LONDON BOROUGH OF HILLINGDON

COMMENTS ON THE EXAMINING AUTHORITY’S SECOND WRITTEN QUESTIONS

HIGHWAYS ENGLAND'S RESPONSE

Figure 14.1: Construction Compound 5 1 in 100 year plus climate change floodplain.

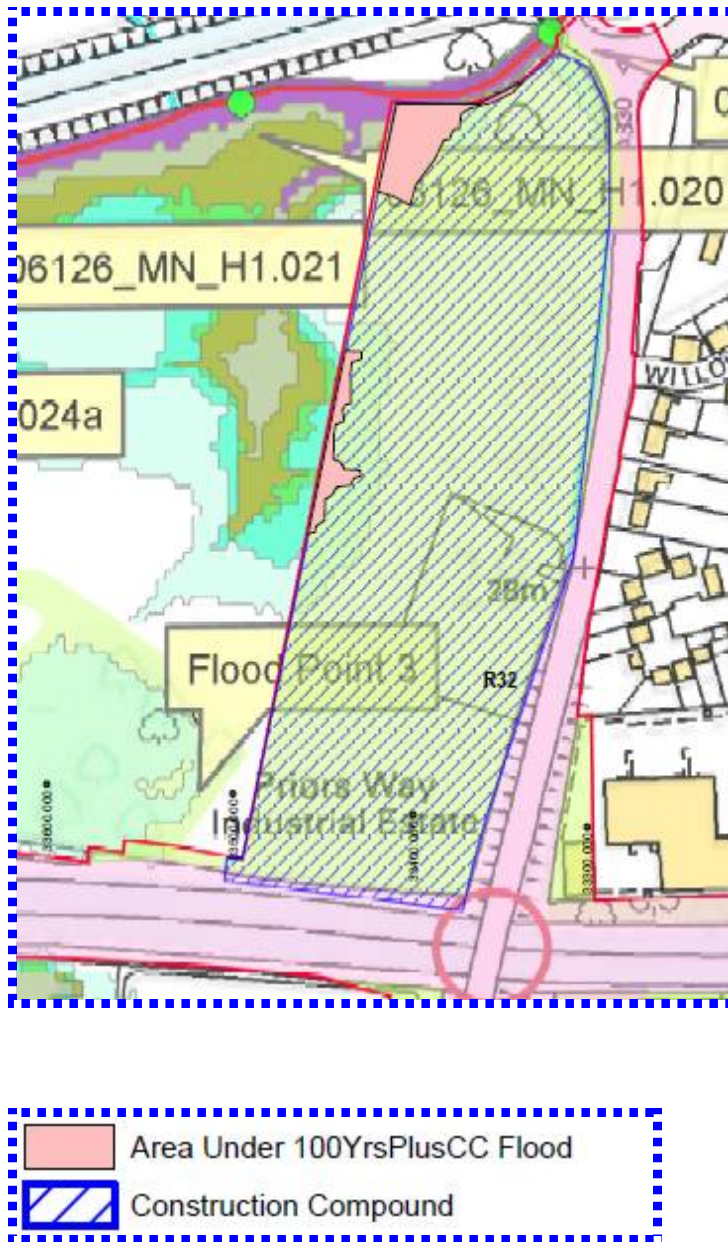
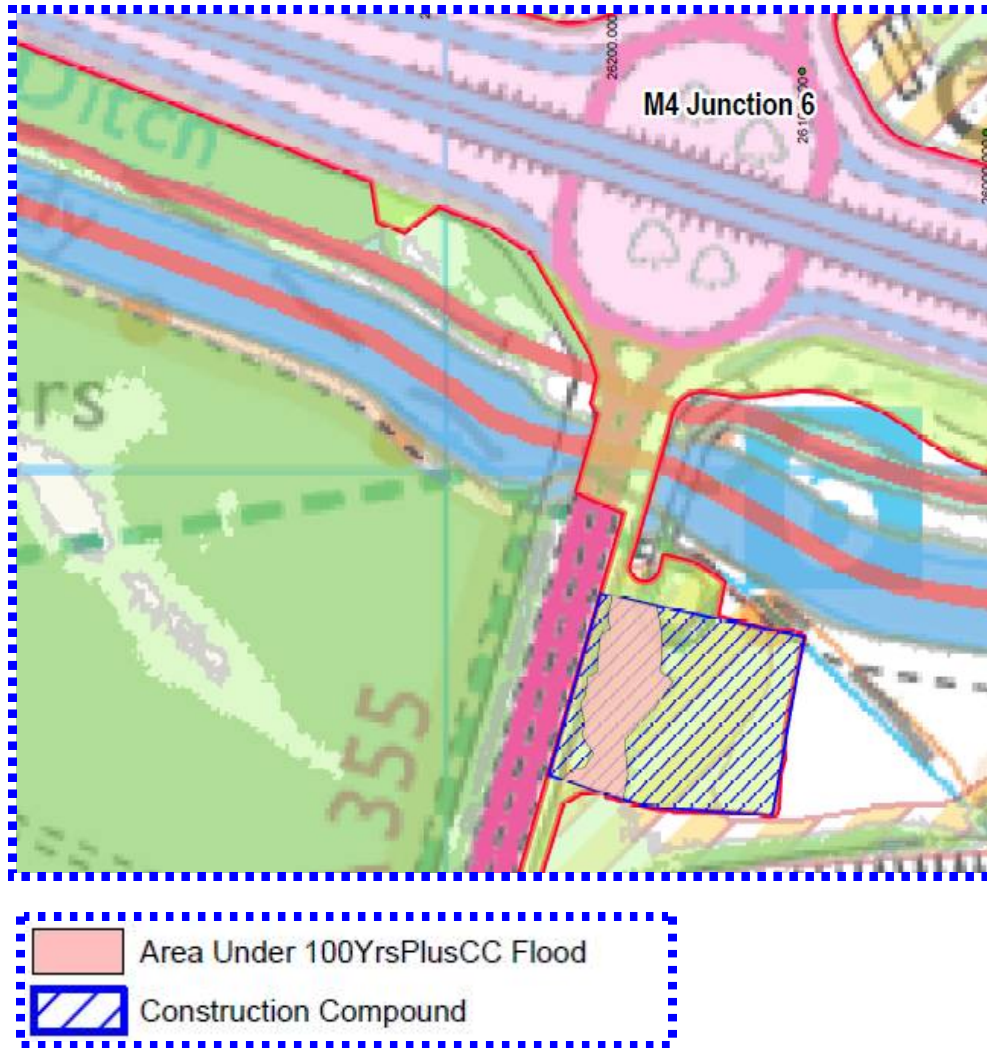
4.3 Flooding		
<p>4.3.1</p> <p>Can the applicant confirm that the following documents will be submitted at Deadline V without fail, or sooner if possible? These documents should be discussed and agreed with the relevant statutory authorities.</p> <ol style="list-style-type: none"> i. Updated Flood Risk Assessment ii. Updated Drainage Strategy Report 	<p><i>The Council are still awaiting an updated FRA and therefore all comments issued with regard to Flooding by London Borough of Hillingdon (LBH) are still relevant.</i></p>	<p>A copy of the updated Flood Risk Assessment (“FRA”) and Drainage Strategy Report (“DSR”) were issued at Deadline V (REP5-002).</p> <p>The main updates to the FRA are as follows:</p> <ul style="list-style-type: none"> • Supplementary description of hydraulic links to floodplain compensation storage areas and a new set of plans (Annex I) illustrating these links in outline. • Assessment of flood risk to construction compound sites and mitigation proposals for the two compounds (Nos. 5 and 7) found to be partially located in the floodplain defined by the 1 in 100 year flood event plus an allowance for climate change.

Question No	<i>LB Hillingdon Comment</i>	Highways England Comments
		<ul style="list-style-type: none"> • Additional information regarding securing flood mitigation works, including reference to a new Requirement (No. 26) in Schedule 2 of the draft DCO. <p>The DSR has been updated to provide an assessment of the feasibility of the provision of above ground SuDS both within the Order limits, and on lands outside the Order limits offered for this purpose by the London Borough of Hillingdon and Buckinghamshire County Council.</p> <p>Highways England considers that all comments raised by the London Borough of Hillingdon with regard to flooding are addressed in the Deadline V submission and will seek a meeting to discuss the revised FRA and DSR reports with them prior to Deadline VII, so that both parties can advise the Examining Authority on the latest position at Deadline VII.</p>
